**WEST SUSSEX COUNTY COUNCIL
STRATEGIC PLANNING CONSULTATION**

SUBJECT: FG/109/14-Demolition of 52-56 Ferring Street and construction of a two and a half storey building with accommodation in the roof, to provide a mixed use development of 3 No. two bed flats and 2 No. one bed flats and three retail units at ground floor (Use Class A1).

52-56, Ferring Street, Ferring, West Sussex, BN12 5JP

Figure 4: Proposed Site Plan

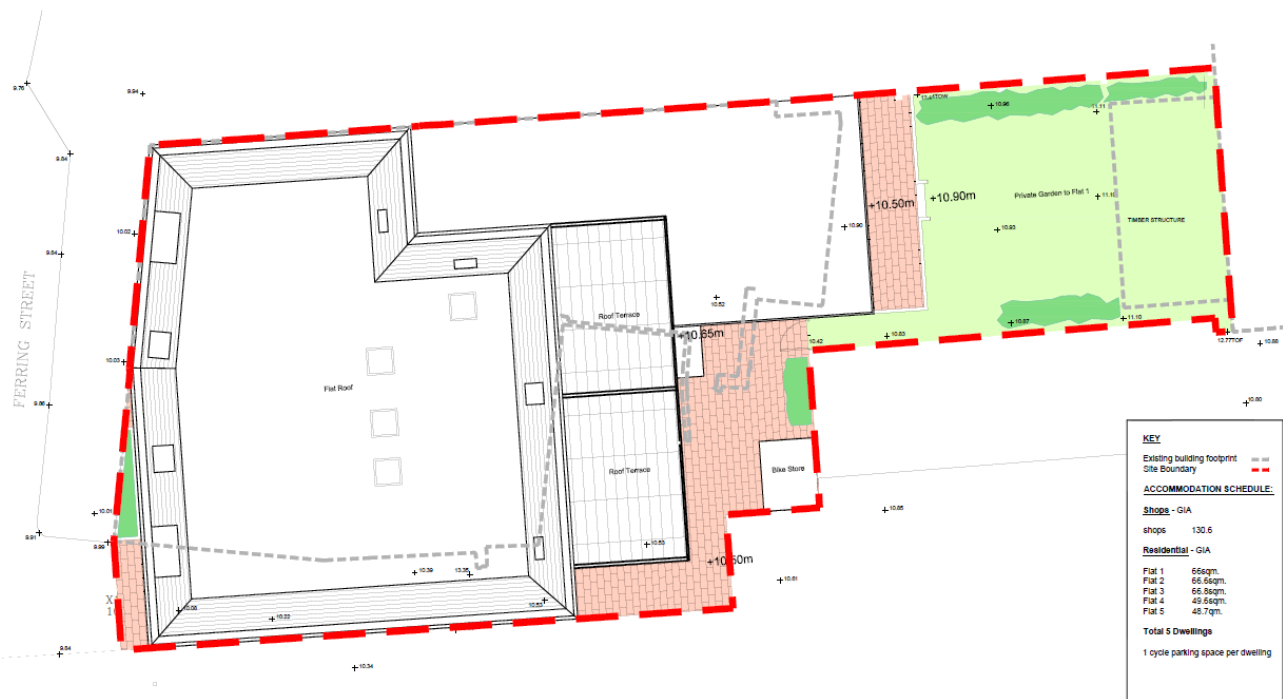
As part of the proposal the existing vehicle access will be closed with the option for additional parking in place of the existing access point. No private parking is provided however note is taken of the sustainable nature of the site near to a variety of bus and rail options. There is a bus stop located immediately to the north of the site which would be available for residents of the proposed flats and customers of the retail units. Cycle storage should be provided and must be secure, covered and capable of holding at least one cycle per bedroom.

The public parking spaces are not within the ownership of the applicant, it would appear they are generally used by customers visiting the existing Newview retail unit. As such, it is anticipated that the three proposed retail units would continue to benefit from these spaces in order to allow customers to park for short periods.

If the LPA are minded to approve this application a condition securing cycle parking and closure of the existing access should be included.
